WEST SUSSEX COUNTY COUNCIL CONSULTATION

TO:	Arun District Council FAO: Anita Gardner
FROM:	Highways, WSCC
DATE:	25/04/2018
LOCATION:	Crossbush Farm Shop, Lyminster Road, Lyminster, West Sussex, BN17 7QN
SUBJECT:	LY/28/17/PL Change of use of existing building from farm shop & cafe to a brewery tap room (bar), fresh coffee bar & cafe & retail space.
DATE OF SITE VISIT:	n/a
RECOMMENDATION:	☒ Advice ☐ Objection ☐ Modification ☐ No Objection ☐ More Information ☐ Refusal
S106 CONTRIBUTION TOTAL:	n/a

Block Plan

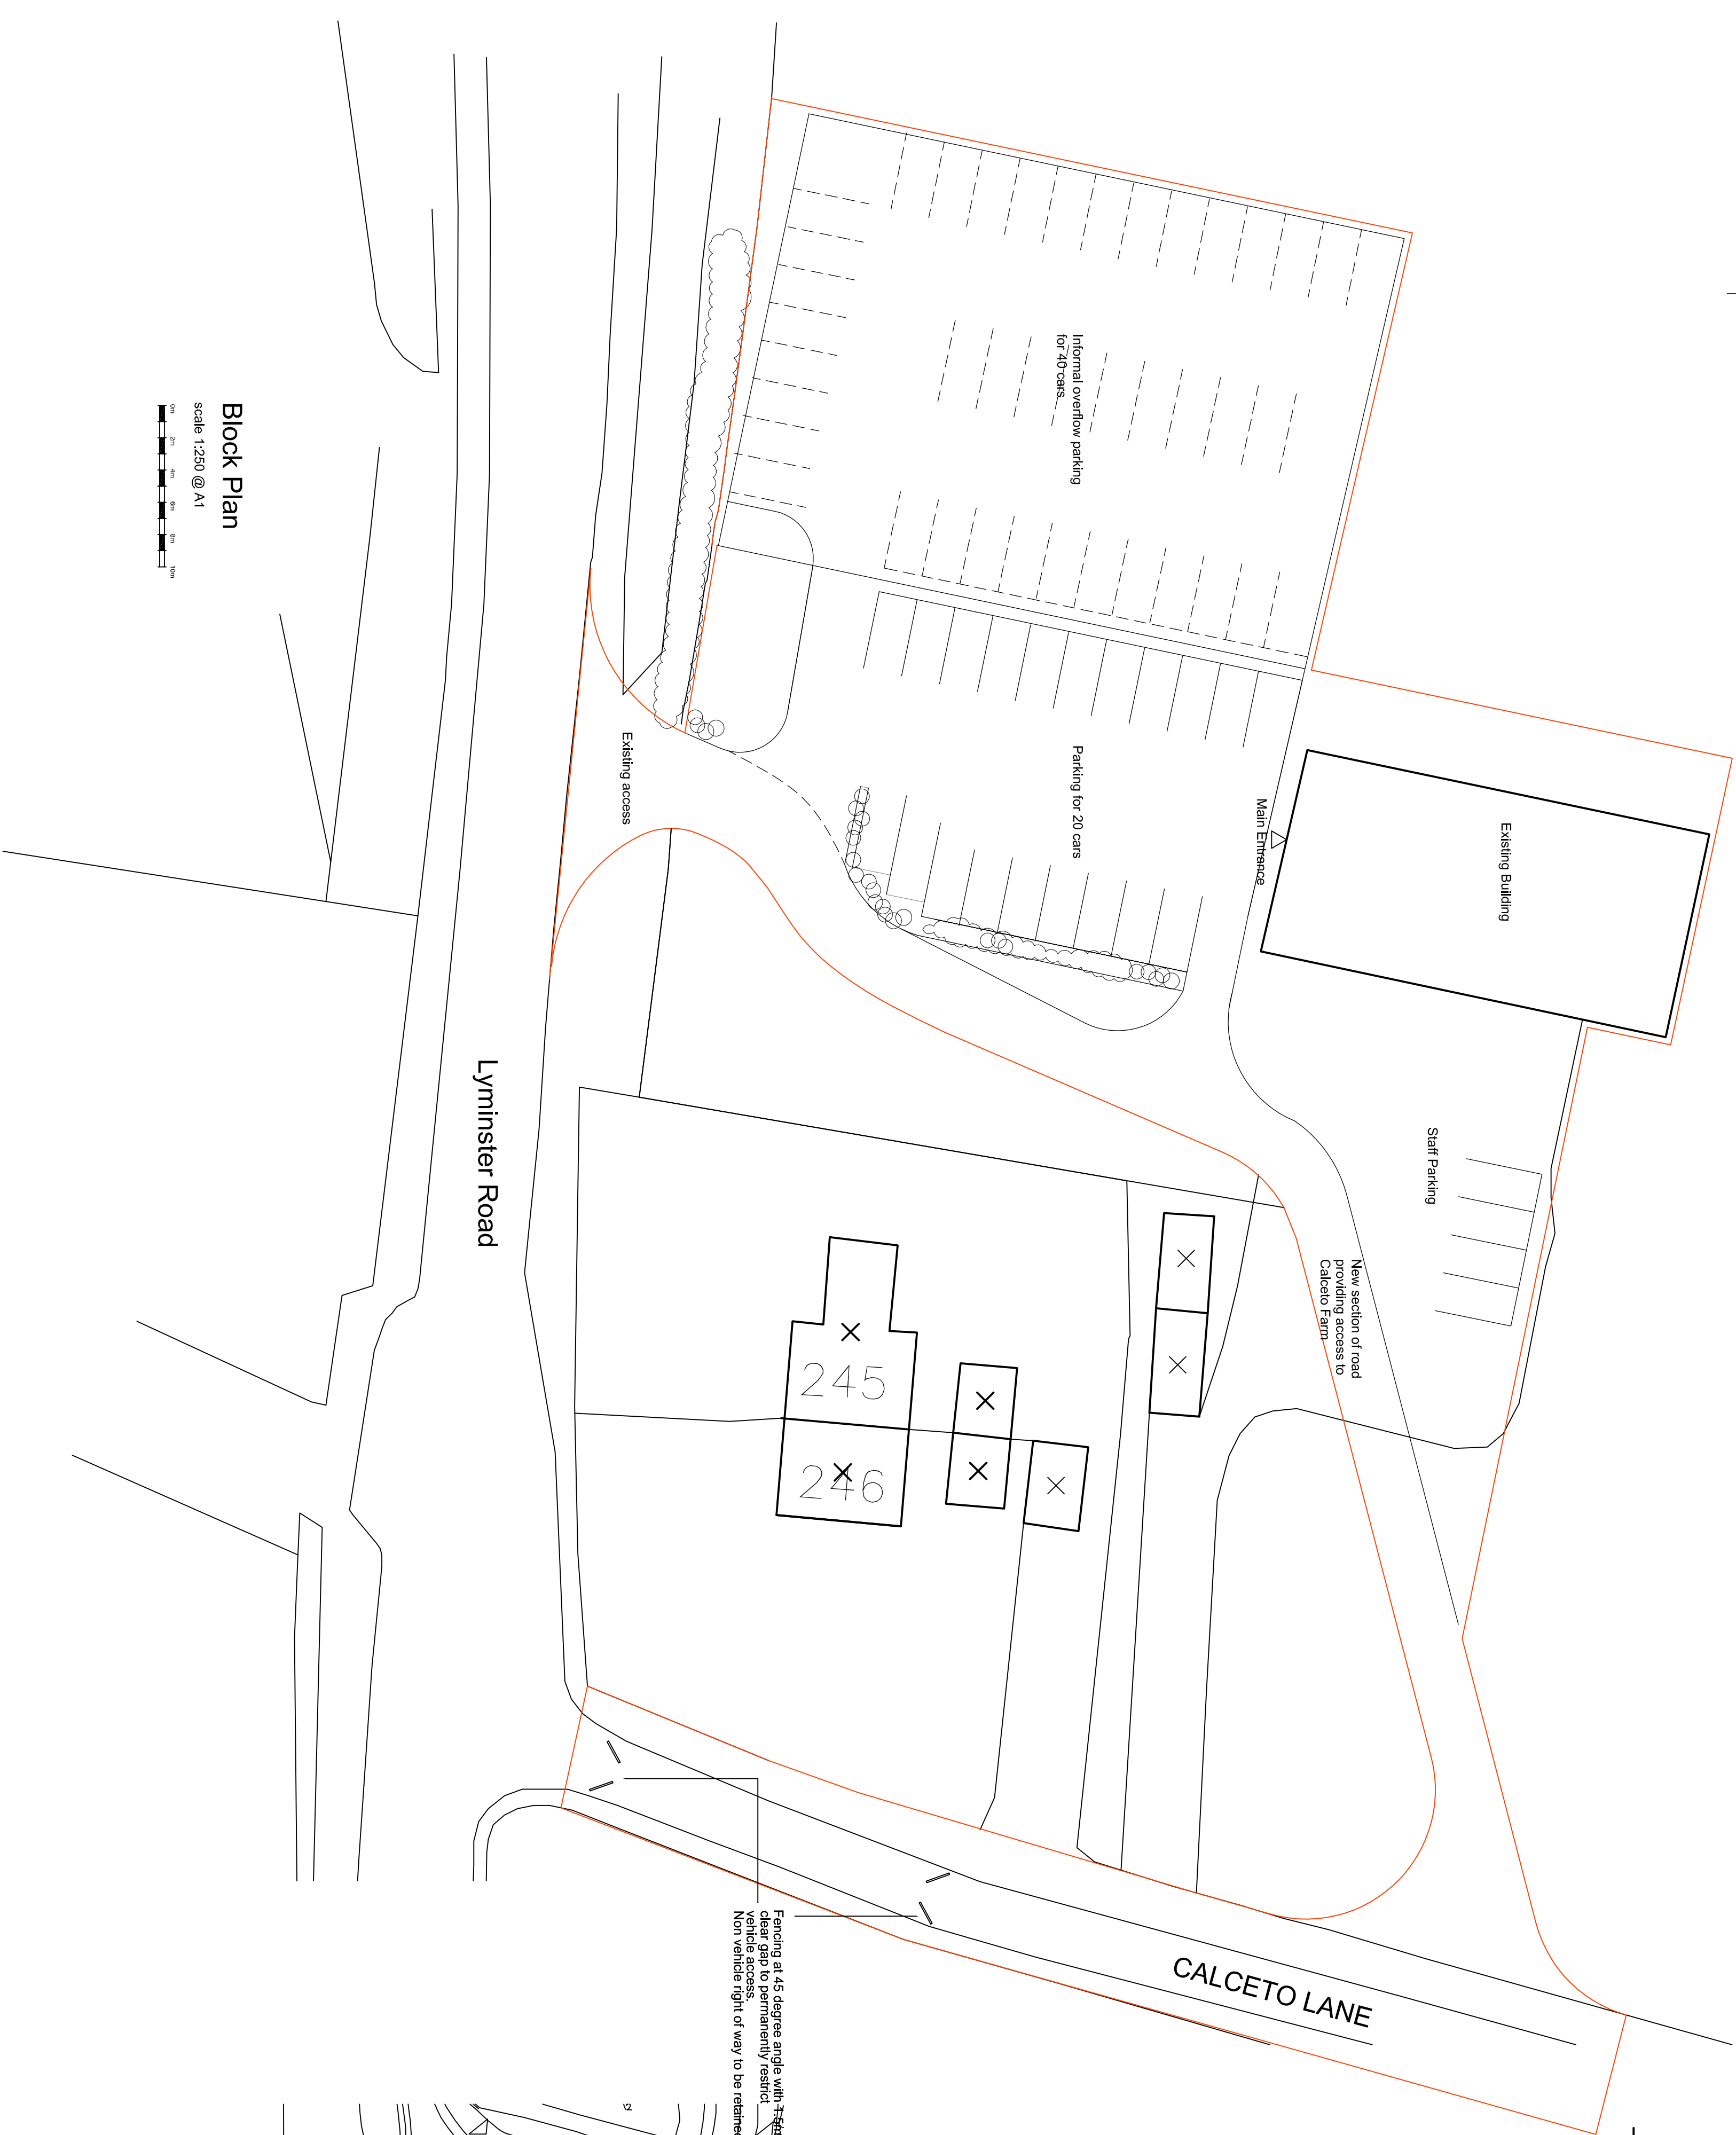
The latest block plan (Rev A) now shows the previously agreed closure works on Calceto Lane to remove access by motor vehicles.

Calceto Lane is a Public Right of Way (F.P. 2205). I have consulted with WSCC Public Rights of Way and they have concerns that the previously approved closure works (45 degree fencing) would restrict the width of the public right of way to an unacceptable degree.

However it has been agreed that in principle a feature such as a bollard could be used to prohibit vehicular movements. As such I would be minded to advise that plans and details be secured via planning condition to agree these works prior to occupation. The applicant would be advised to contact WSCC Public Rights of Way prior to preparing this information for submission/approval.

The applicant has identified that informal overflow car parking for up to 40 additional cars can be accommodated adjacent to the main parking area.

Given the latest parking assessment, which indicates undersupply of 10 spaces, I would be minded to advise a modification whereby the overflow car parking provision is reduced in size to accommodate up to 10 vehicles only. Such a modification can be secured via planning condition.

The use hereby permitted shall not commence until the closure of Calceto Lane for egress of vehicles, has been completed in accordance with plans and details submitted to and approved in writing by the Local Planning Authority Reason: In the interests of road safety
